D APPLICATIONS ON WHICH COMMITTEE 'DEFER' THEIR APPROVAL SUBJECT TO WORK 'DELEGATED' TO THE DIRECTOR OF COMMUNITY SERVICES BEING SATISFACTORILY COMPLETED

APPLICATION REF: 3/2018/0236/P

PROPOSED ERECTION OF 27 LIGHT INDUSTRIAL UNITS, 8 OFFICE UNITS AND ASSOCIATED ACCESS, PARKING AND ANCILLARY WORKS AT FORMER GOLF DRIVING RANGE, UP BROOKS, LINCOLN WAY, CLITHEROE

Drawing file: planx_downloads / 18_0236_Amended_Site_Plan_23Oct18.pdf

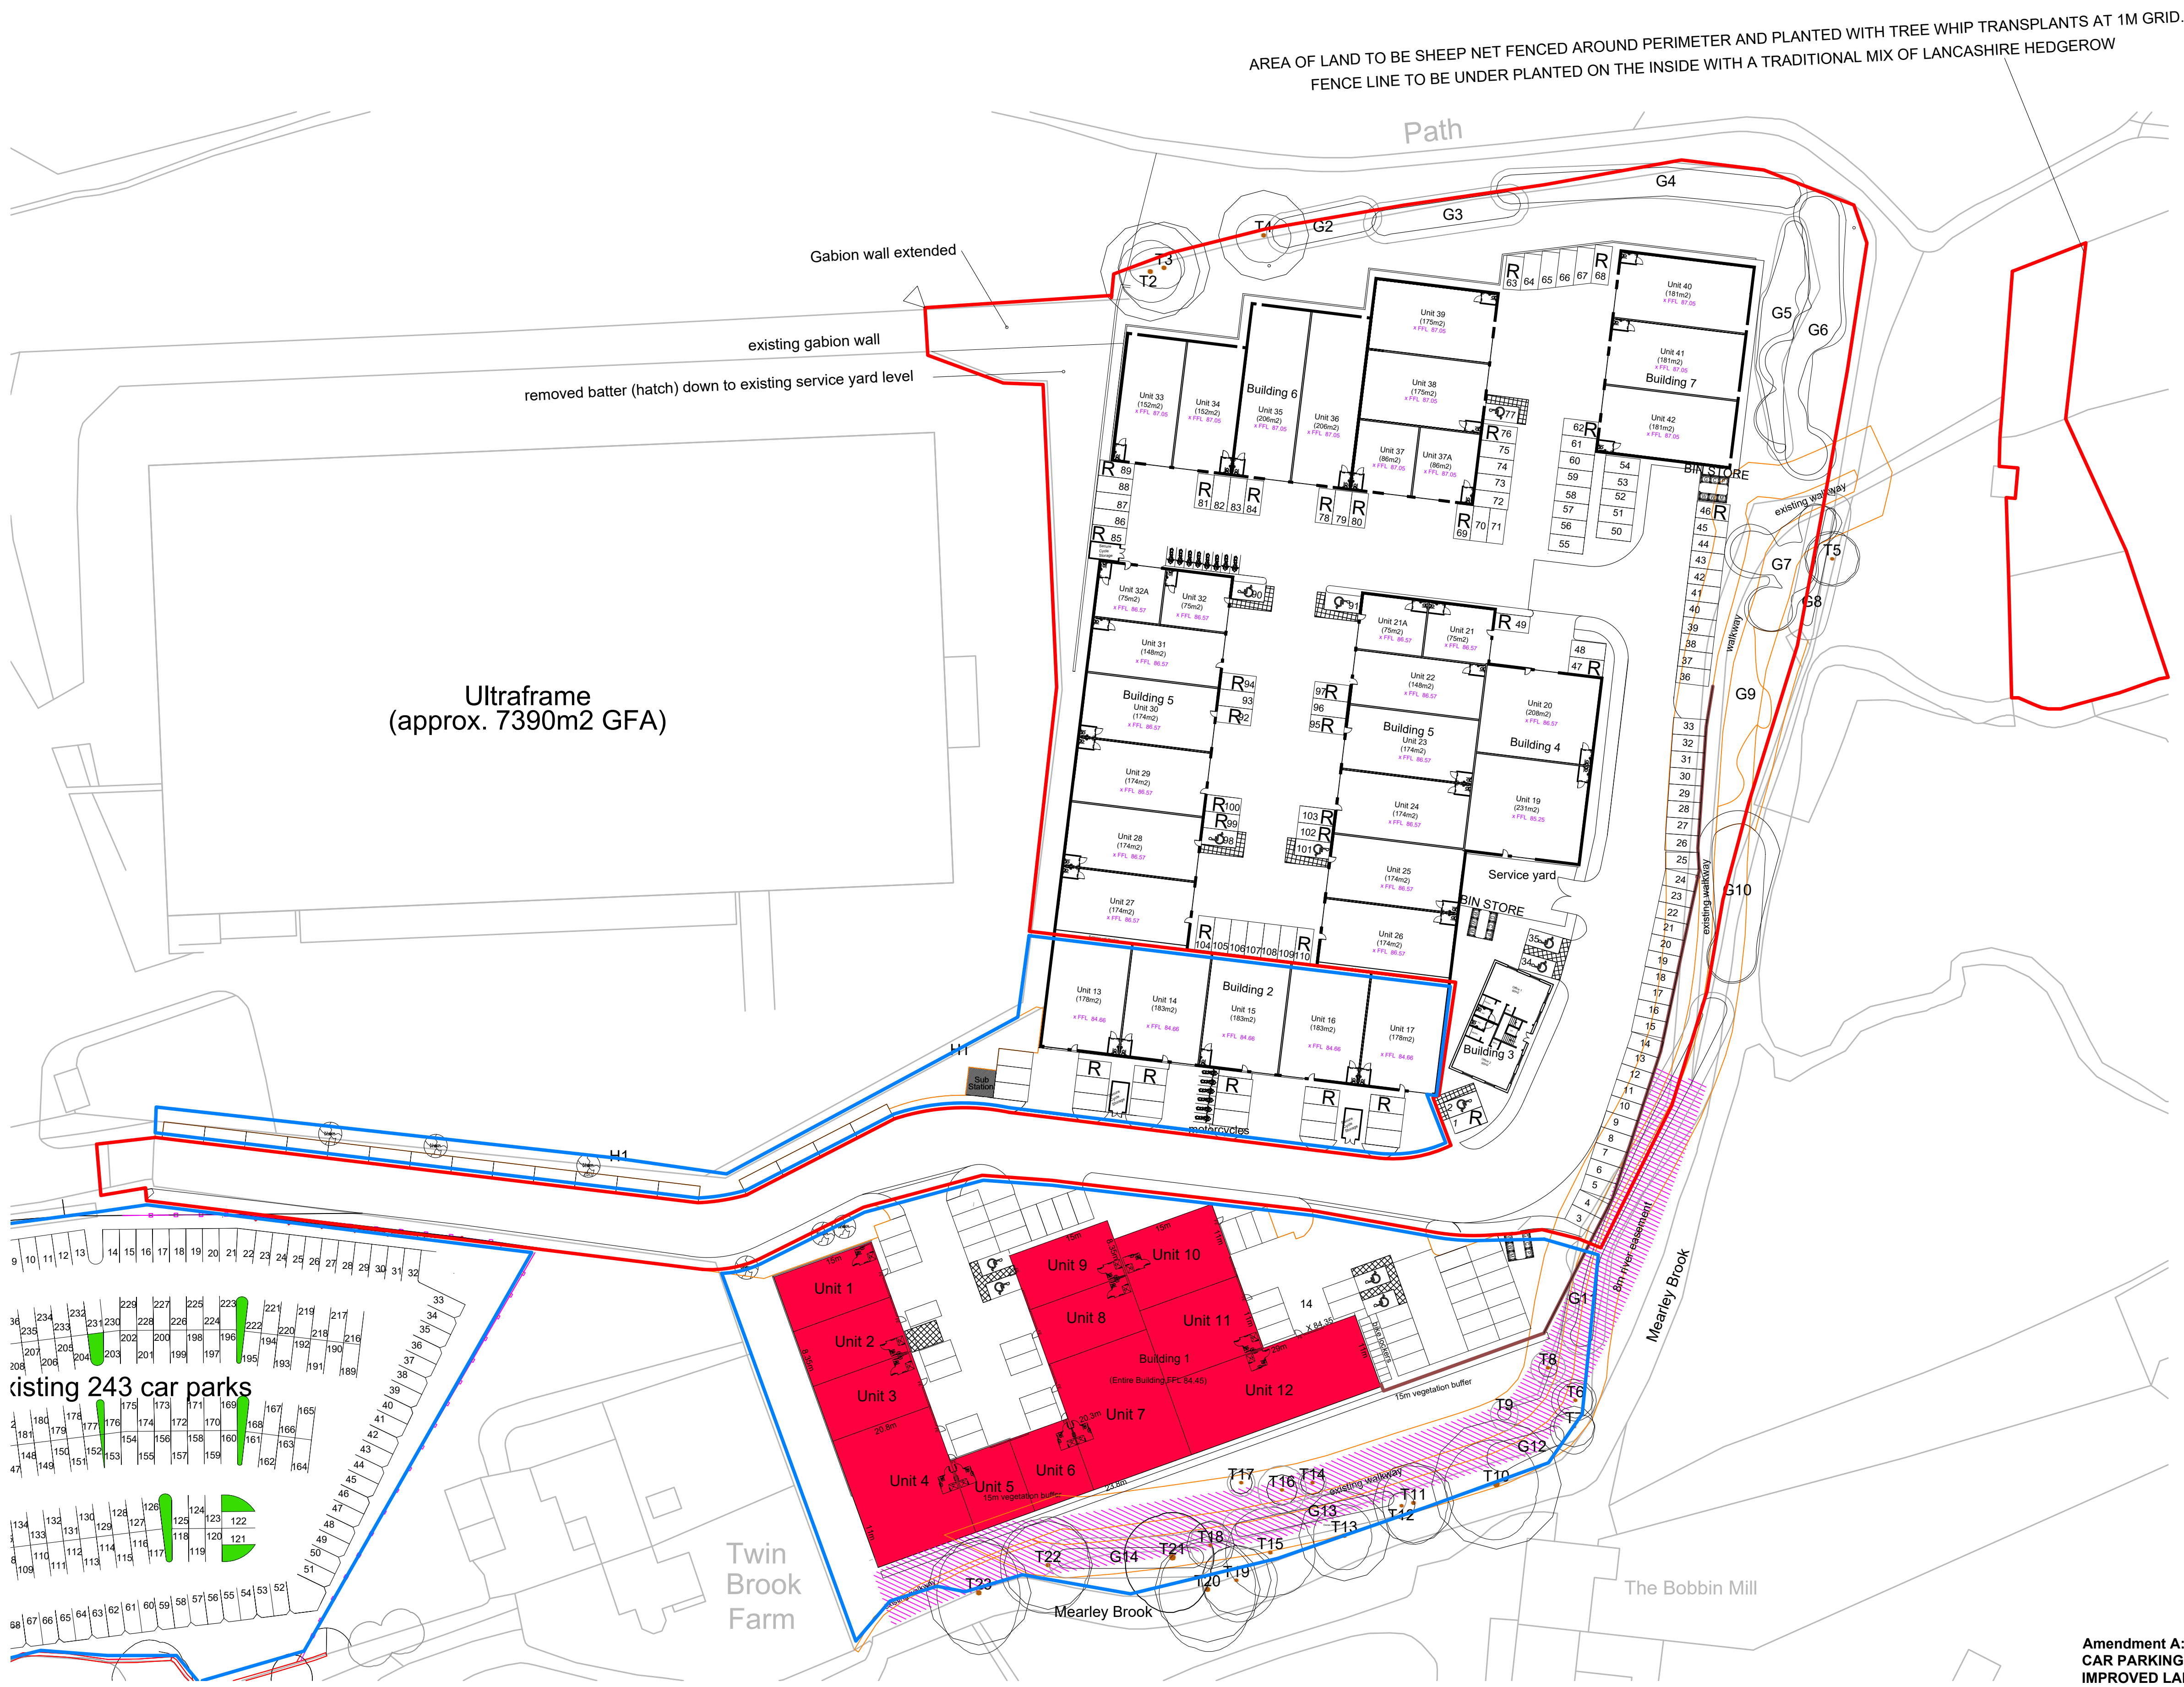
5.2.2 The Highway Engineer has however requested that the mobility standard parking spaces numbered 34 and 35 (adjacent to Building 3) are omitted as these have poor visibility when exiting. The spaces could, however be accessed via the adjacent service yard.
